Morris Goding
Access Consulting

11 Gibbons Street, Redfern

**Access Review -
Final**

25 September
2018

Project Number
Drawing Name
Scale
Date
11929
Adaptable Unit Layouts
1:50@A1
September 2018

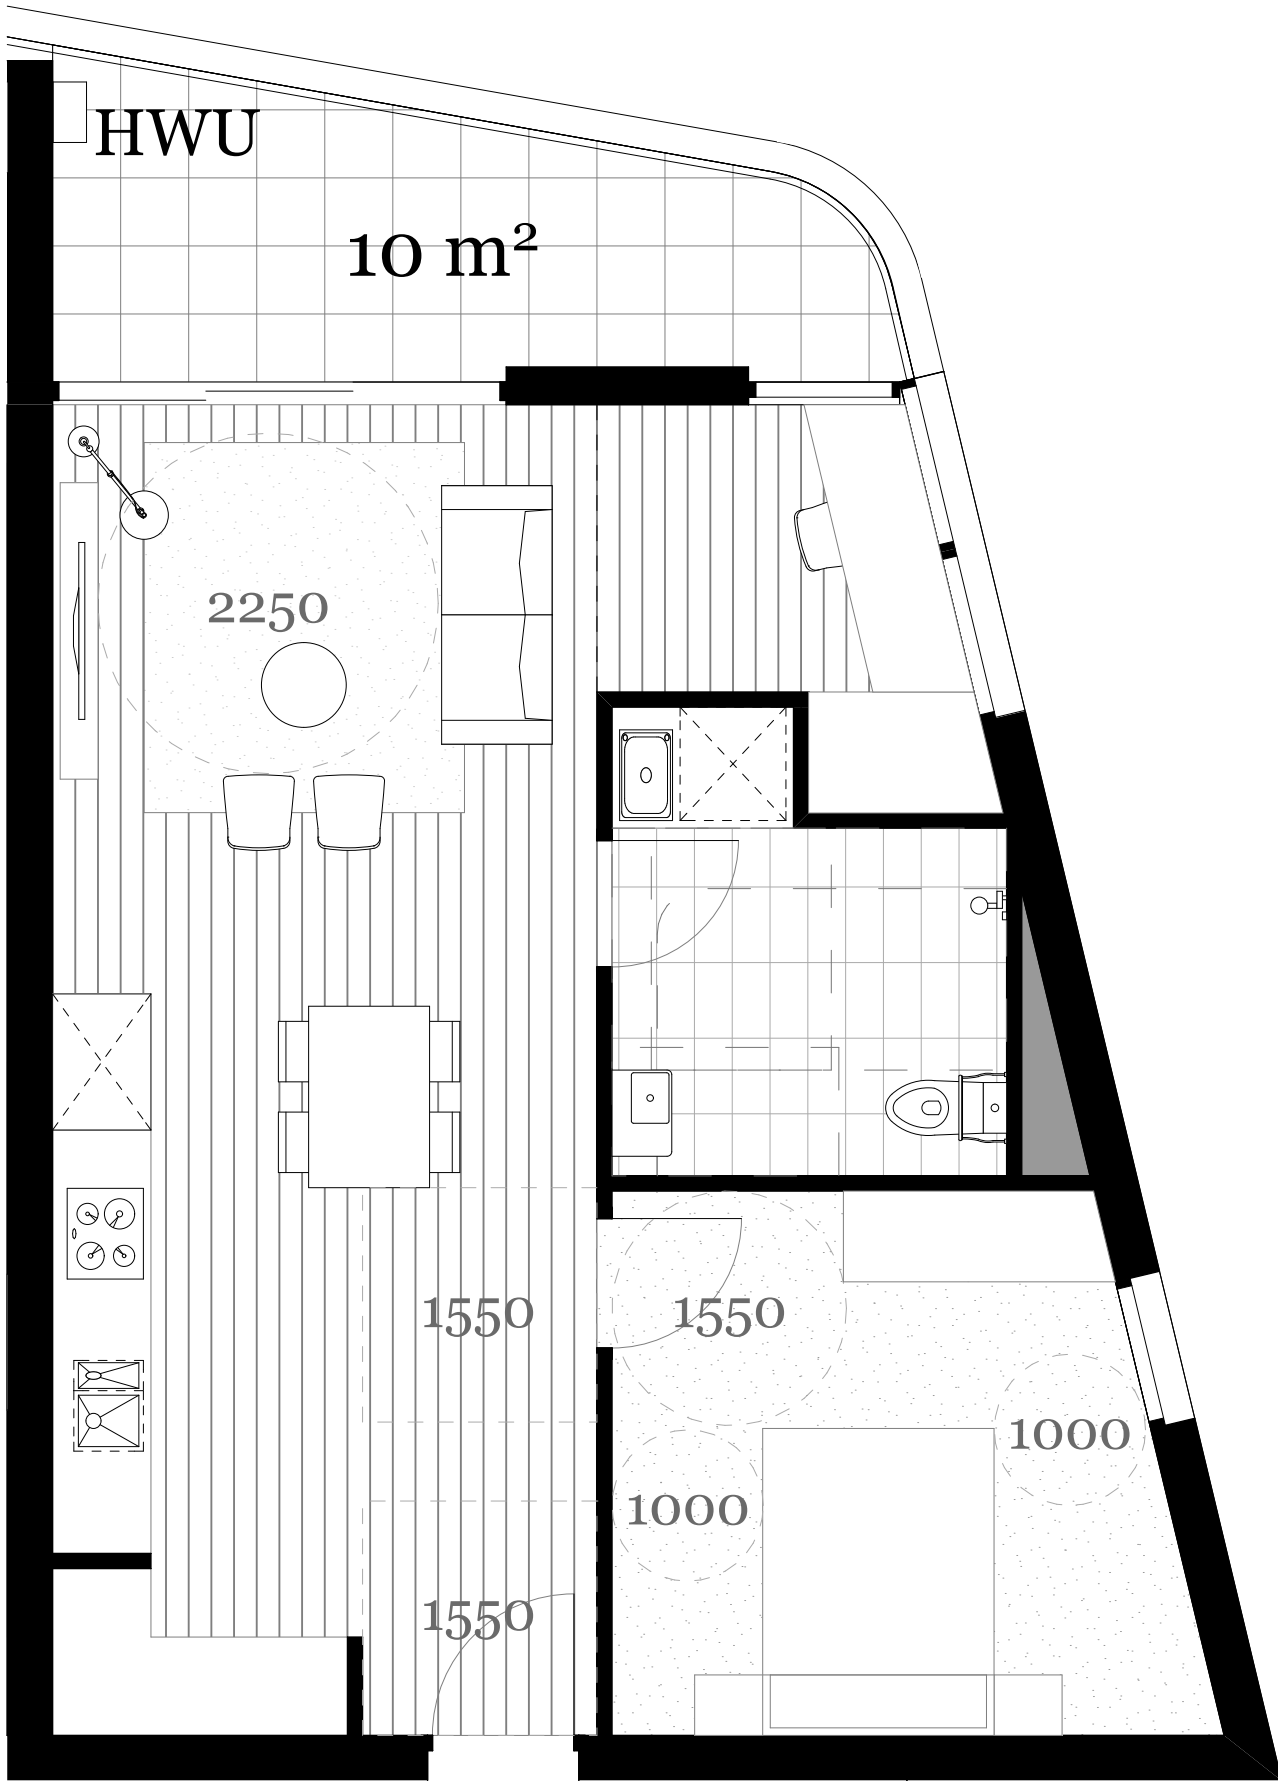
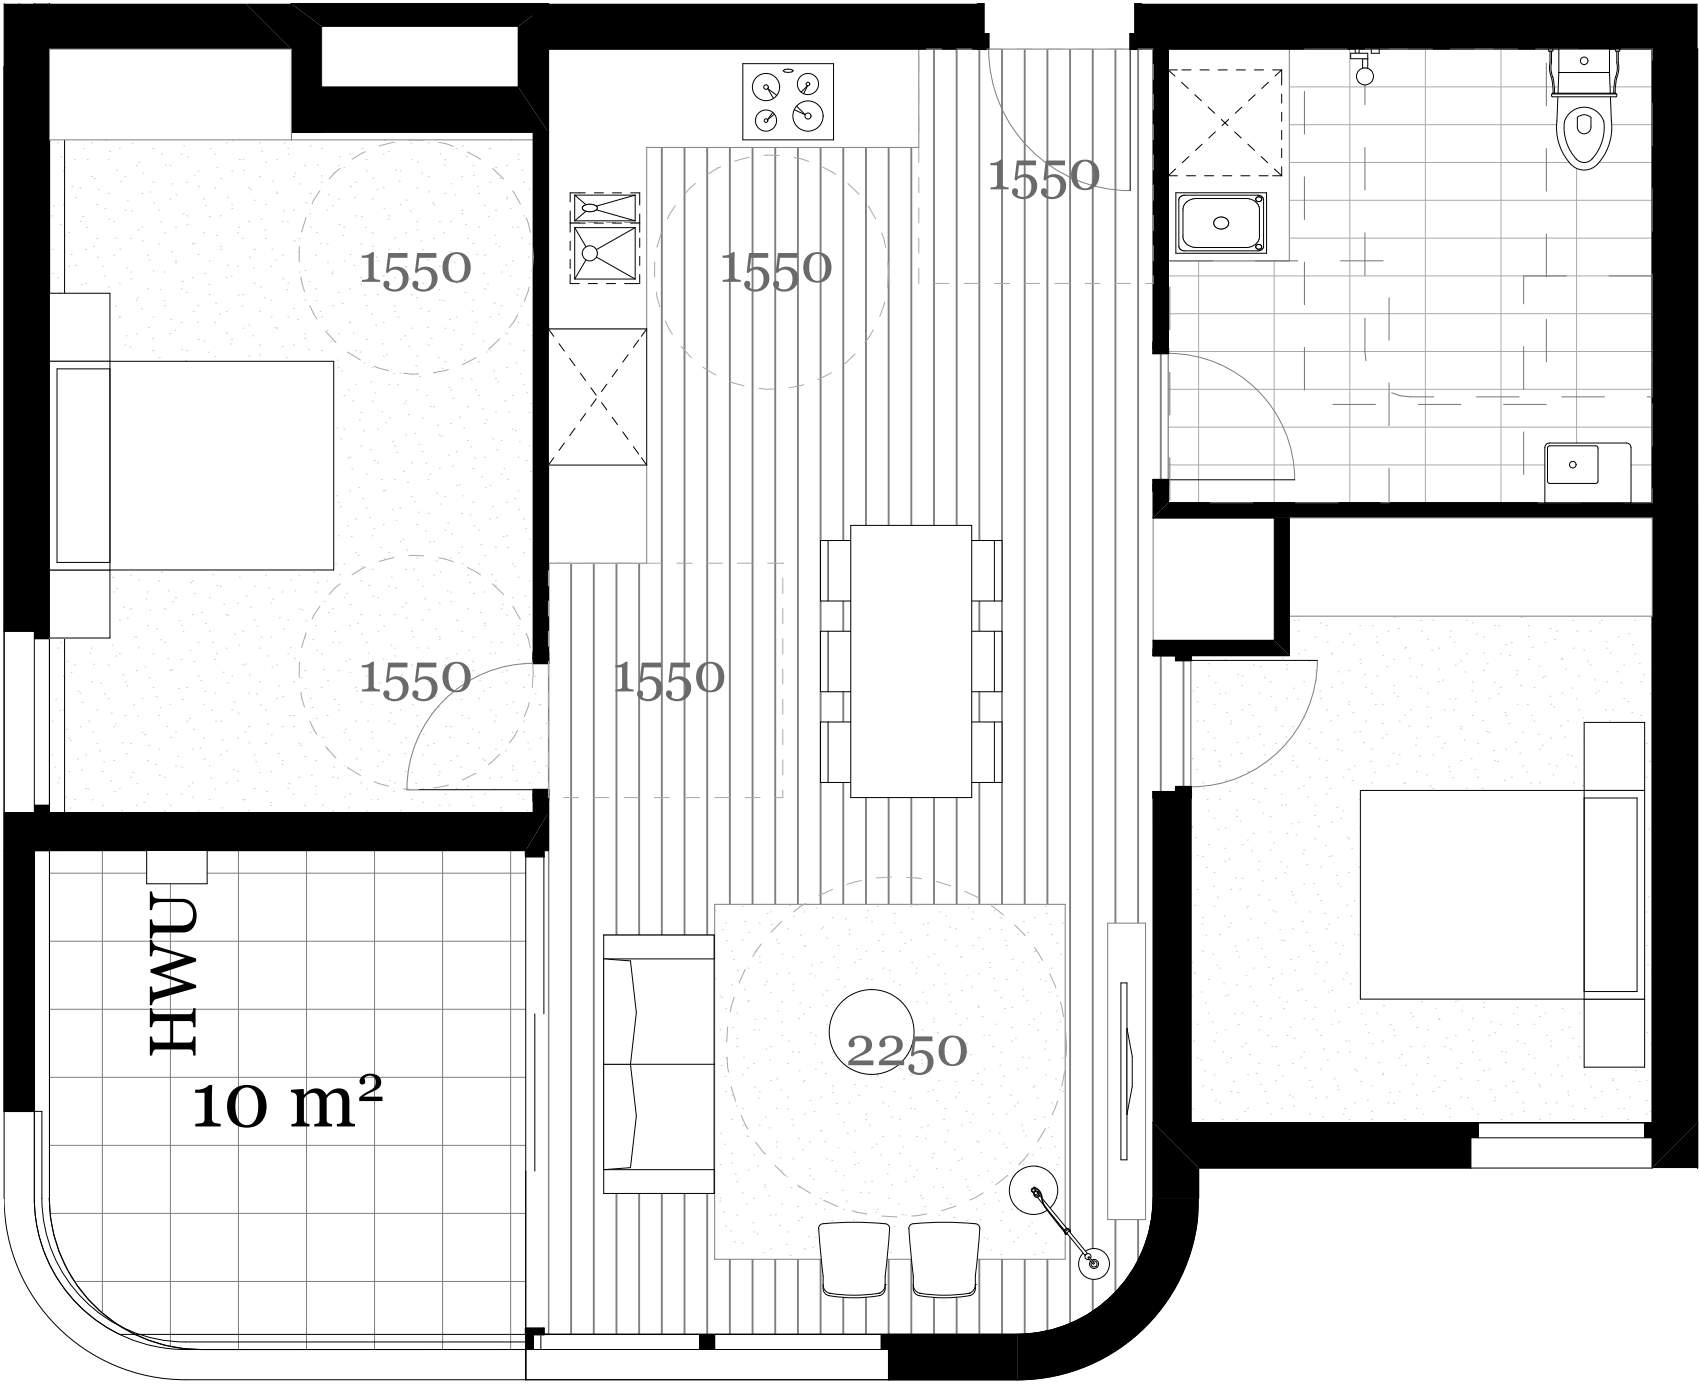
A minor adjustment is required in the bathrooms to allow the adaptable unit shower to be adjacent a side wall for future reinforcement.

A minor adjustment is required in the bathrooms of the 2 bedroom adaptable unit to allow the shower to be adjacent a side wall for future reinforcement.
